WALDEN PRESERVE 2, FILING NO. 4

REVISION DATE: SEPTEMBER 13, 2018 (PER UPDATED TITLE COMMITMENT)
DATE OF PLAT PREPARATION: MAY 31, 2018
WALDEN PRESERVE 2, FIL. NO. 4 - PT. SW1/4 SEC. 14, PT. SE1/4 SEC. 15, PT. NE1/4 SEC. 22 & PT. NW1/4 SEC. 23, T11S, R66W of the 6th P.M., EL PASO COUNTY, CO

PCD File No. SF-18-034

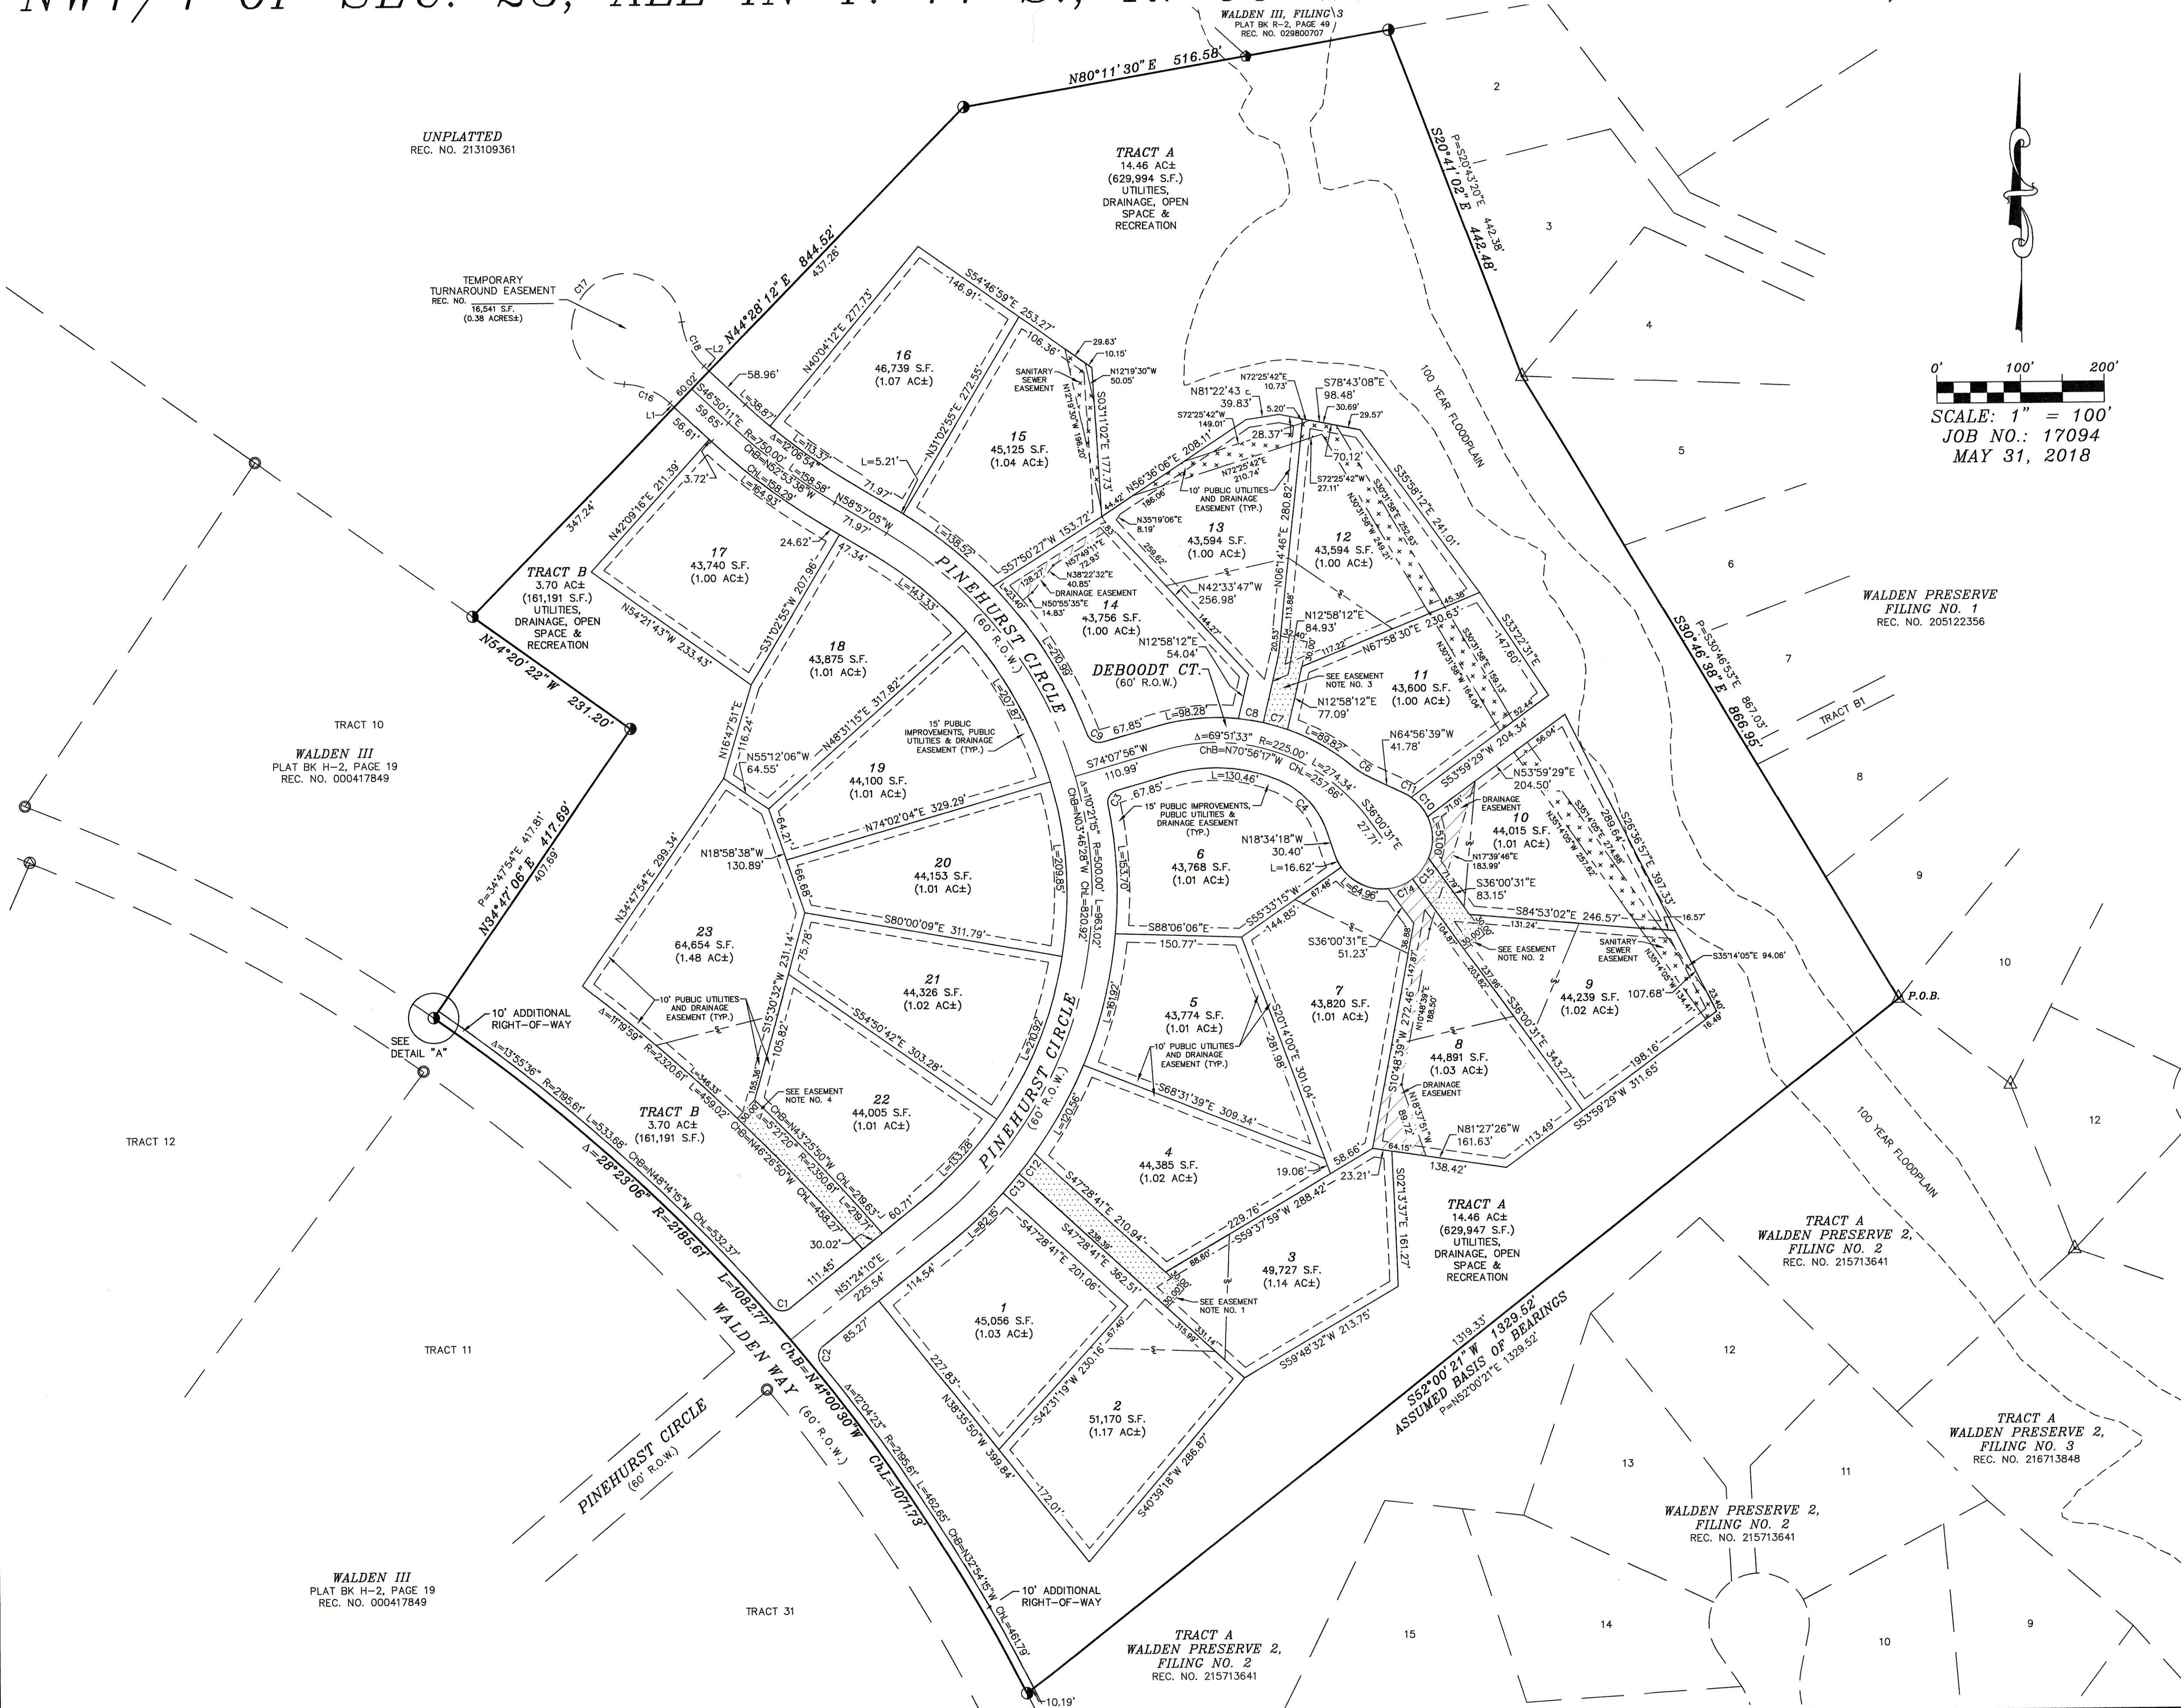
Provide a drainage easement for the drainage ways.

Delineate the 100yr flood plain.

Provide the street name.

Provide a temporary turnaround. See ECM Section 2.3.8.C for the criteria and language that needs to be included in the plat.

access or more than 3 lots is considered a roadway and not a driveway.

DRAWING: 17094FP4.DWG PAGE 1 OF 2

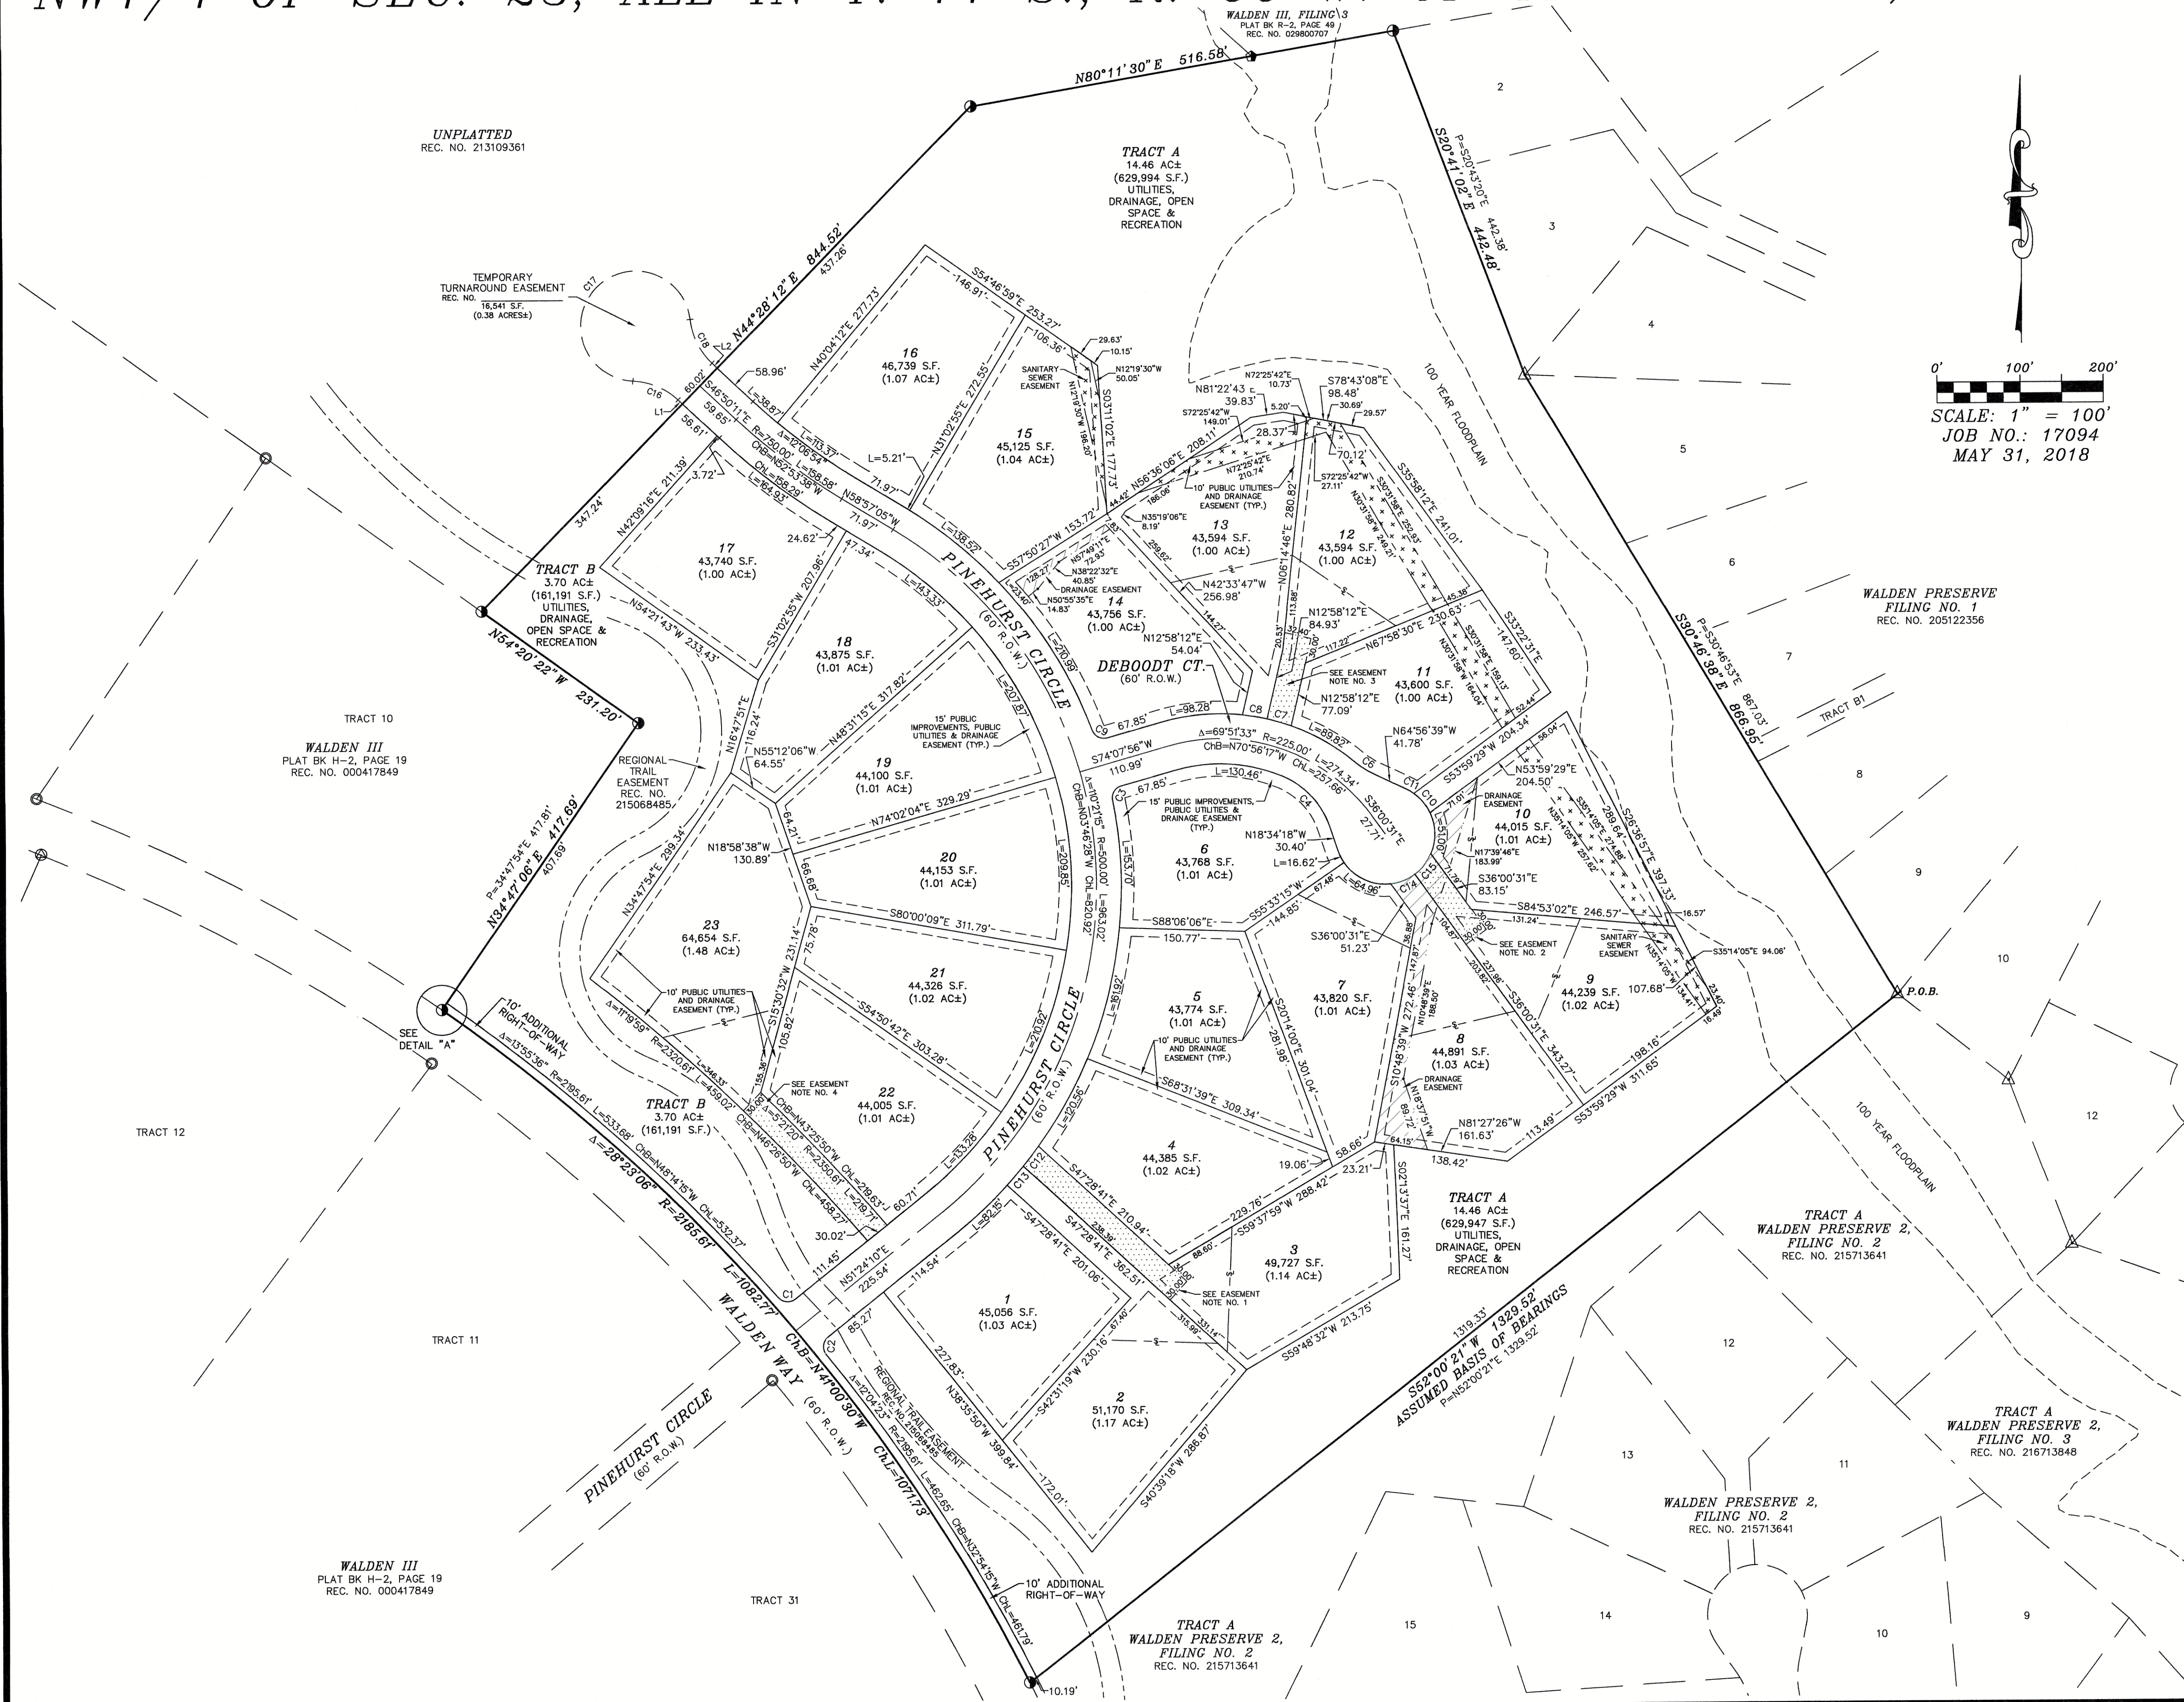
Add the following notes:

- No driveway shall be established unless an access permit has been granted by El Paso County.

- No improvements shall be placed within the high water line of the reservoir or in the spillway or spillway channel. If development activities associated with this subdivision result in required modifications, repairs, enlargements to, or replacement of, any dam, spillway, spillway channel, or other water detention facility located within, or associated with, this development, developer, the homeowners' association, and/or the dam owner shall be responsible or liable for such modifications, repairs, enlargements, or replacement and the costs thereof. However, El Paso County shall not be responsible or liable for such modifications, repairs, enlargements, or replacement and the costs thereof by virtue of this subdivision approval.

1. Driveway access is limited to 3 lots or less. Private roads serving 4 lots or more shall be built to public road standards. Is the intent to construct a private road?
 - a. If so, then update the construction plans and drainage report to include P&P, details, and analysis regarding the private road. Additionally access spacing for a private road at lots 11,12,13,14 would not meet intersection spacing.
 - b. If not, then revise the notes and easement width accordingly. The previous PUD only provided a 30' common easement for the benefit of the two flag lots at each location.

2. The developer shall provide a maintenance agreement for these shared private access. Update the notes to reference the reception number for the maintenance agreement.

Revise to Resolution 16-454

Fill in the blanks for note 13. The information should have already been recorded.

Delete "Department of Transportation"

fill in all blanks other than items to be recorded with the plat

An additional setback line has been shown in the PUD and preliminary plan. Please show the setback line on the final plat.
